CHARLOTTE-MECKLENBURG
PLANNING COMMISSION
INTER-OFFICE COMMUNICATION

SUBJECT: Administrative Approval for petition 93-40 Baumann Press Inc. Tax Parcel #107-313-05 and 107-312-17

SUBJECT: Administrative approval for Petition No. 93-40 Baucom Press,
Tax Parcel No. 107-313-05,17.

SITE PLAN - PHASE III
1" = 20'-0"

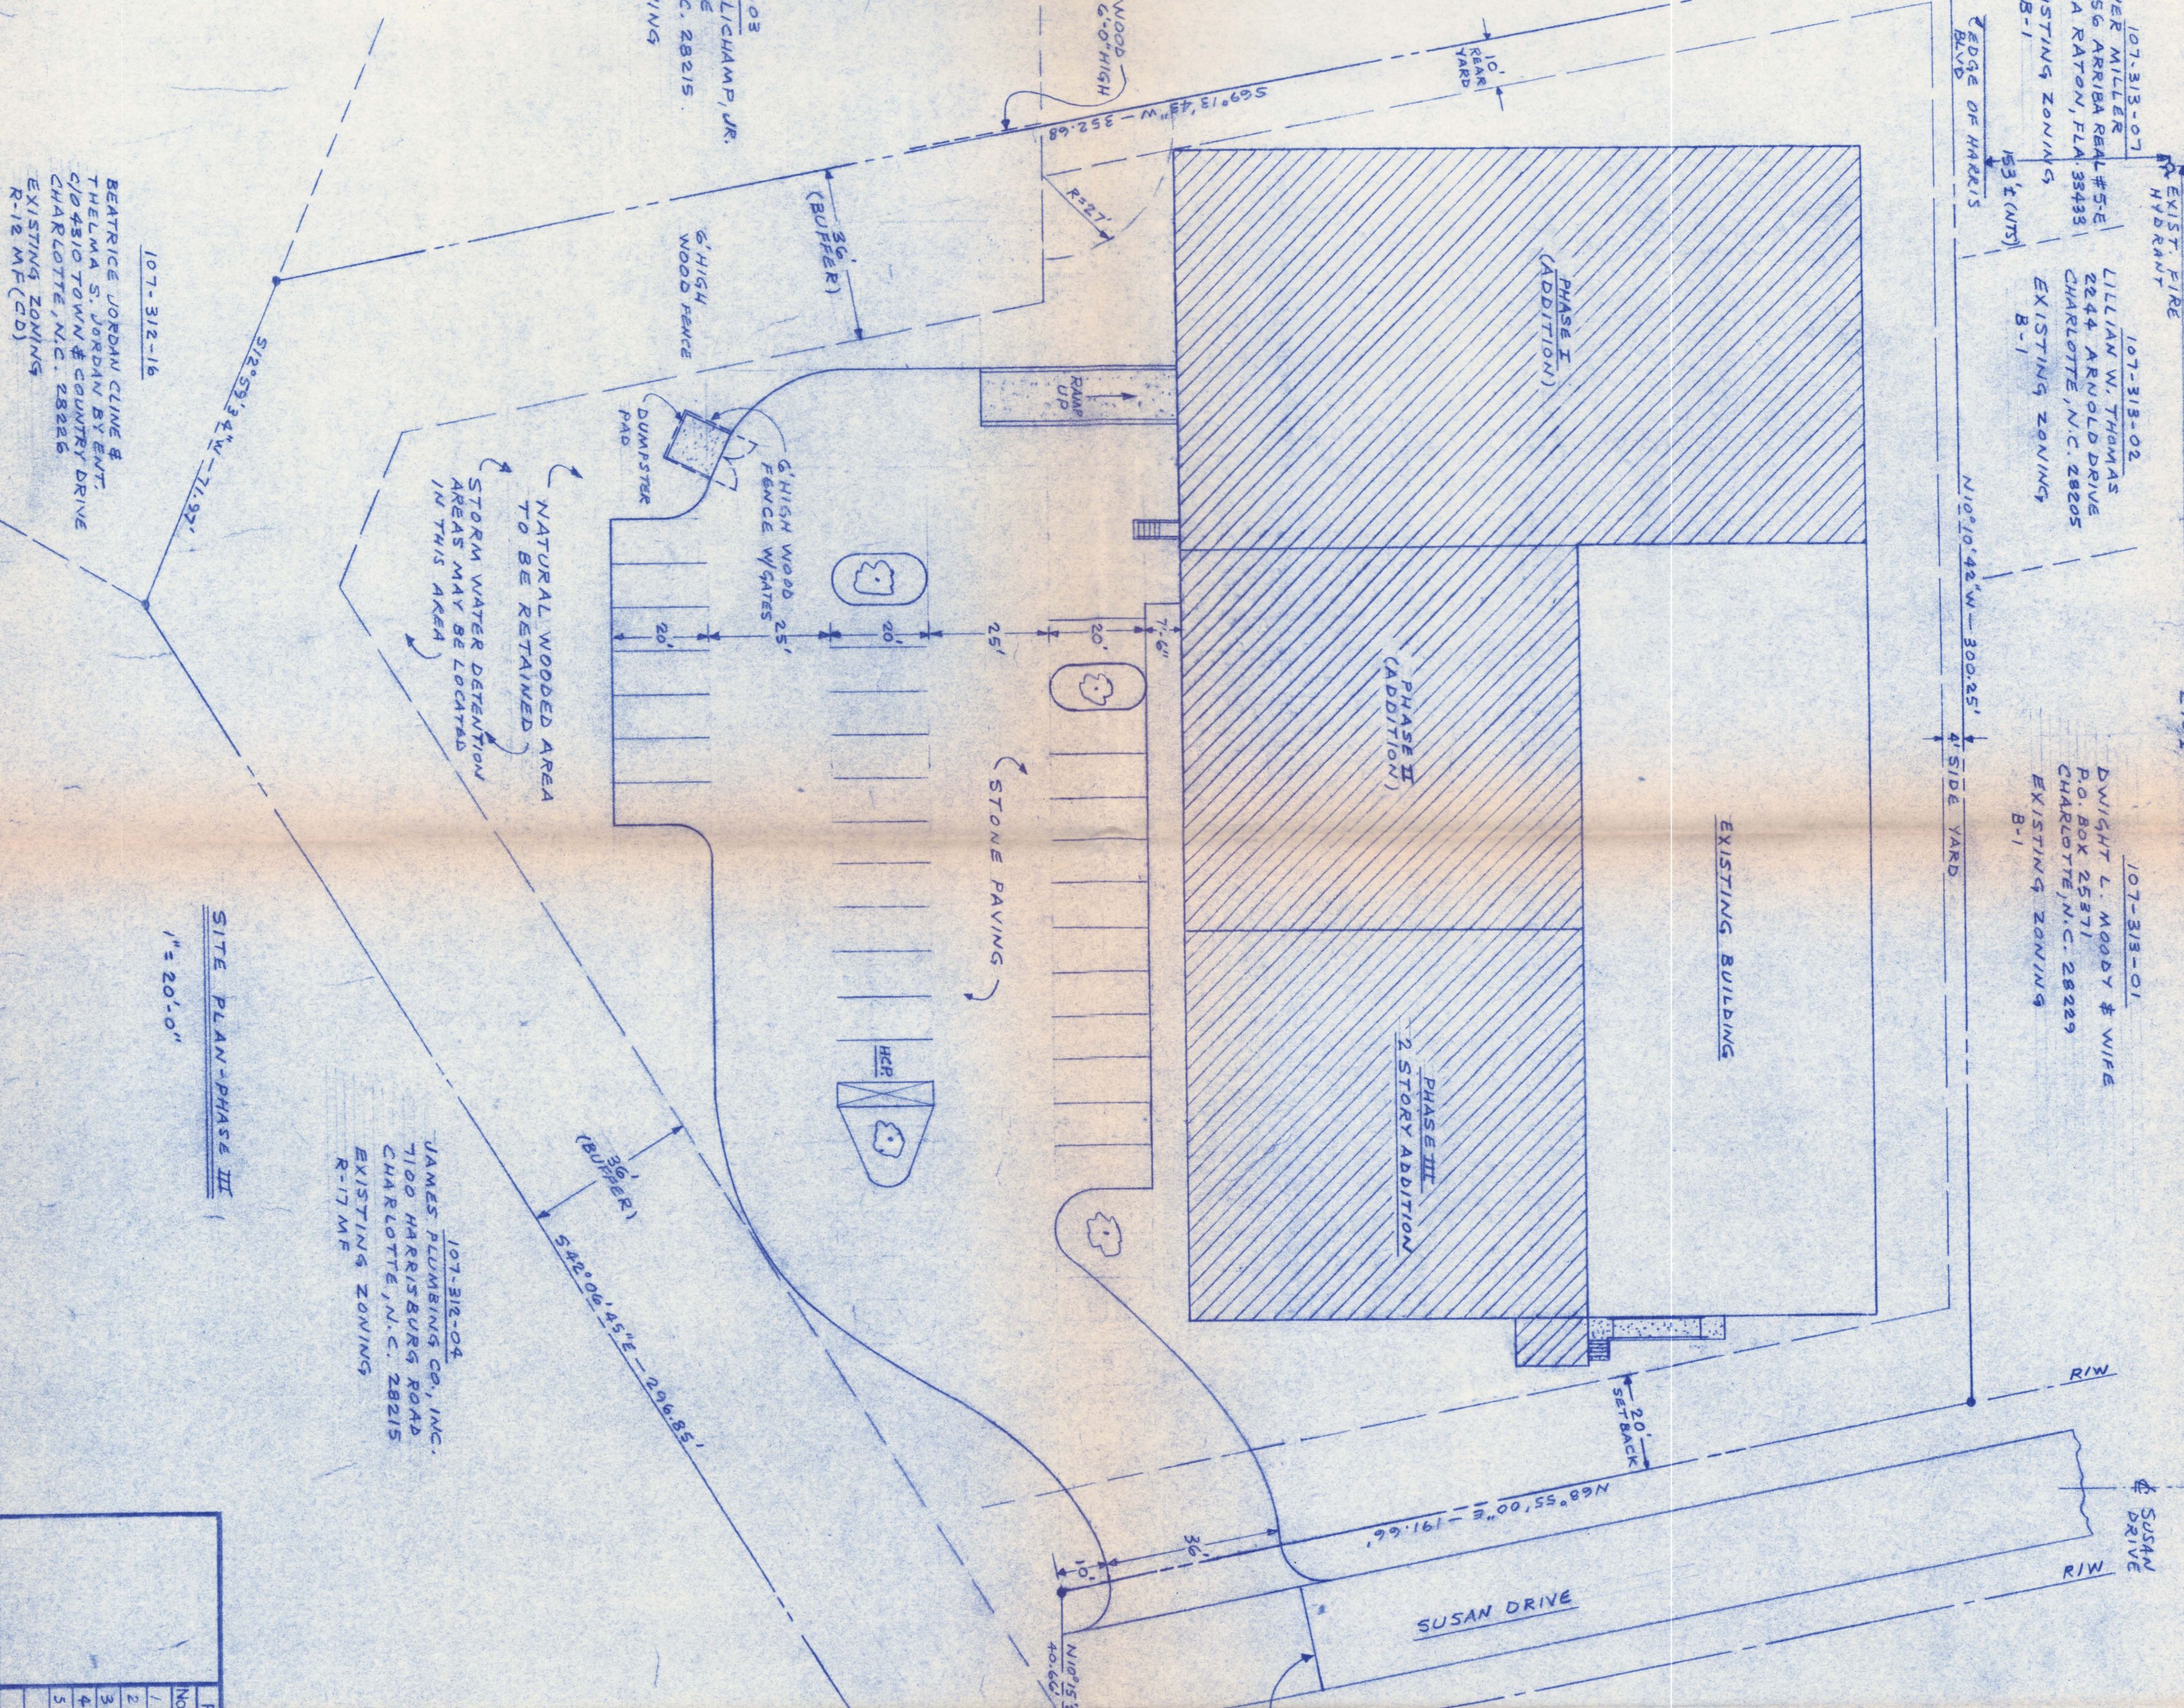
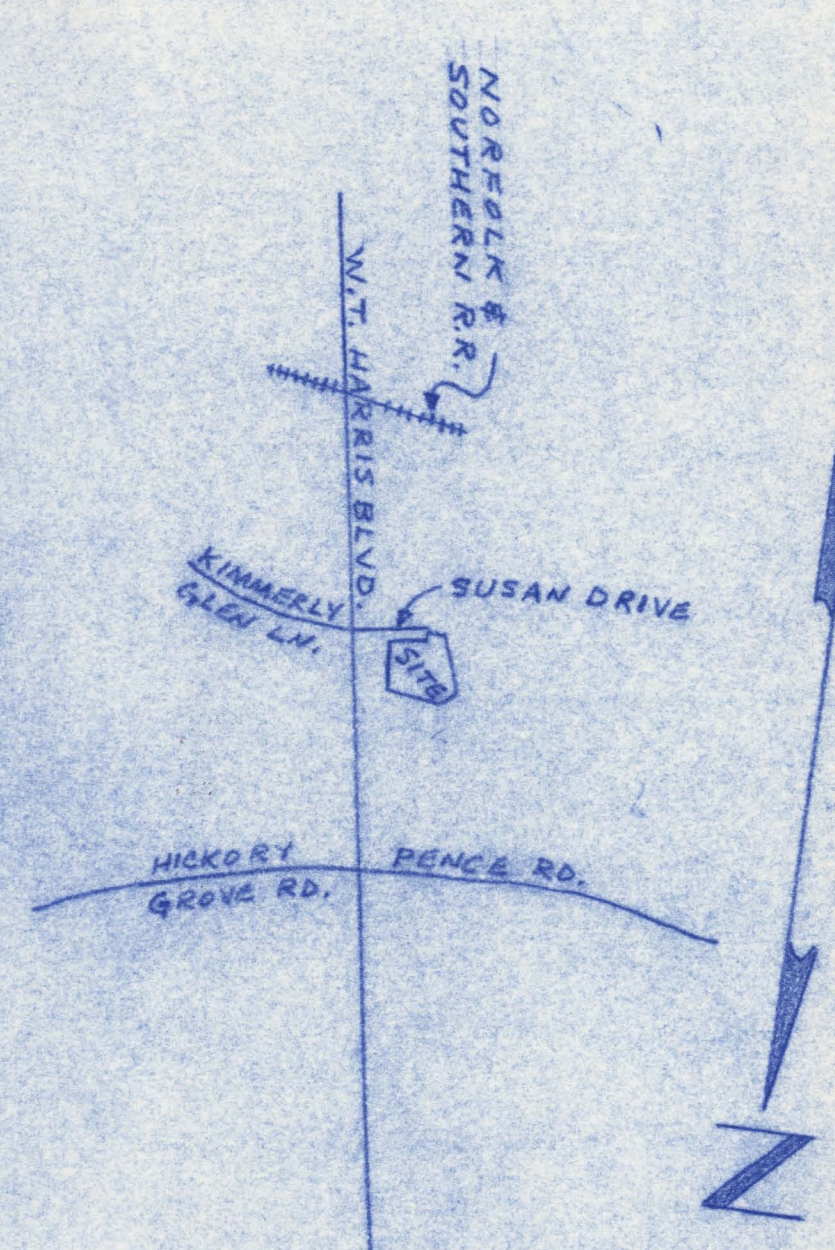
Attached is a revised plan for the above mentioned rezoning petition. The plan has been revised to modify the buffer along the eastern property line. This buffer was modified to accommodate a 15 foot sanitary sewer easement that was installed by C.M.U.D. The new buffer will be 27 feet wide exclusive of the 15 foot sanitary sewer easement and will include a six foot fence and 21 trees. This modified buffer still meets the minimum requirements of a class B buffer as required by the approved conditional plan. Since these changes do not significantly alter the conditions of the approved conditional plan I am administratively approving this revised plan. Please use this plan when evaluating requests for building permits and certificates of occupancy.

Attached is a revised plan for the above mentioned rezoning petition. The plan has been revised to allow the petitioner to relocate the driveway to the existing section of Susan Drive. The potential building area has been reduced from 42,000 square feet to 27,800 square feet and somewhat alters the parking arrangement. The building envelope has also been modified to allow construction up to the four (4) foot sideyard along the west side of the property. All other items of the original conditional site plan remain unchanged.
